**WEST SUSSEX COUNTY COUNCIL
STRATEGIC PLANNING CONSULTATION**

SUBJECT: BR/95/15/PL - Demolition of existing garages & erection of a two storey 4 No. studio apartment block.

Rear of 22 Stocker Road, Bognor Regis, PO21 2QF

DRAWING
**LOCATION PLAN
SITE PLAN**
DRAWING No
142/01

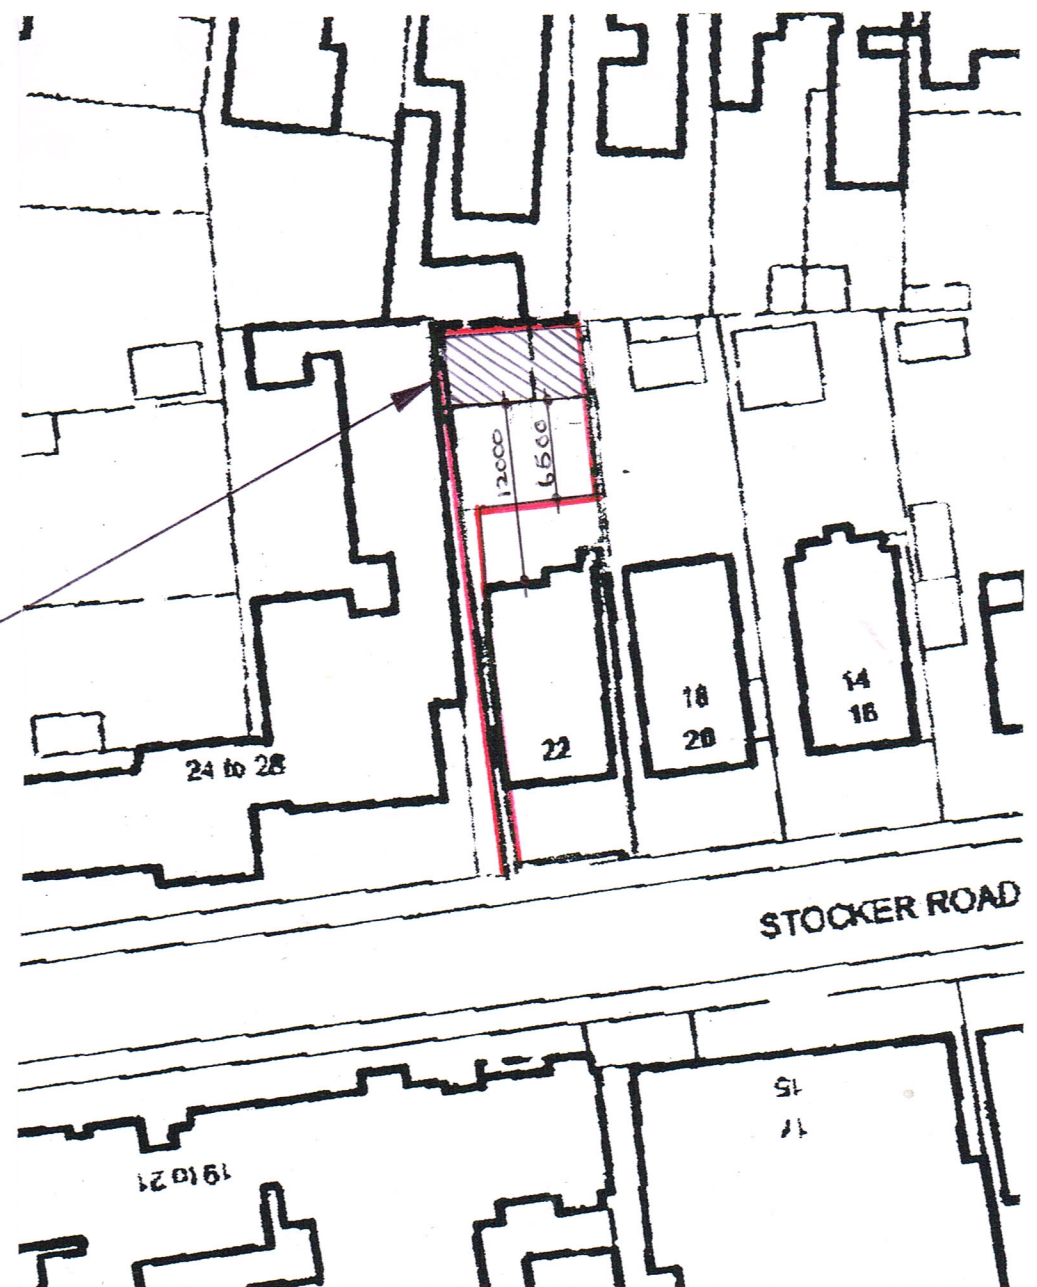
From inspection of the plans and information available, the site is currently not offering off-road parking for the new units. However, the site is situated within a sustainable location with good access links to public transport; therefore potential occupiers may not have to rely on a private vehicle. Whilst there are no highway safety concerns in this, the proposals may lead to an increase demand in on-street parking within the area which the LPA may wish to consider from an amenity aspect.

The site will also offer cycle storage which should be secure and covered and capable of holding up to 4 cycles.

No concerns wished to be raised to this application from a highways perspective subject to condition securing cycle parking.
